Letter No. B 2/2170/2003

Sub: CMDA - Area Plans Unit - Planning Permission - Proposed construction of Residential Building Ground+Mezzanine+2F with 4 dwelling units at Plot No.11, State Bank Officer's Colony 1st Street, Arumbakkam, Chennai, T.S.No.11/6, Block No.15 of Arumbakkam - Remittance of Development Charge and other charges - Reg.

MEZZANINE FLOOR PLAN

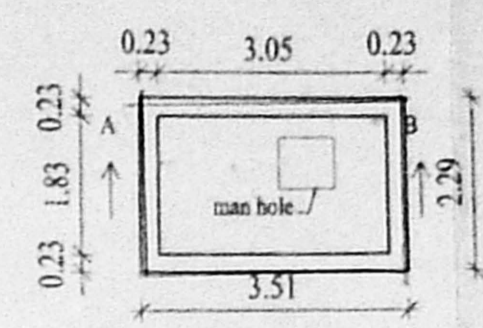
- Mazzanine floor height to be shown as minimum 2.75m, based on that total height of the building and side set back dimension to be rectified.
- Usage of building to be mentioned in the title of the plan.
- Dimension of percolation trench to be shown.
- Dimension of building and column position at 1st and 2nd floor do not tally with ground floor.
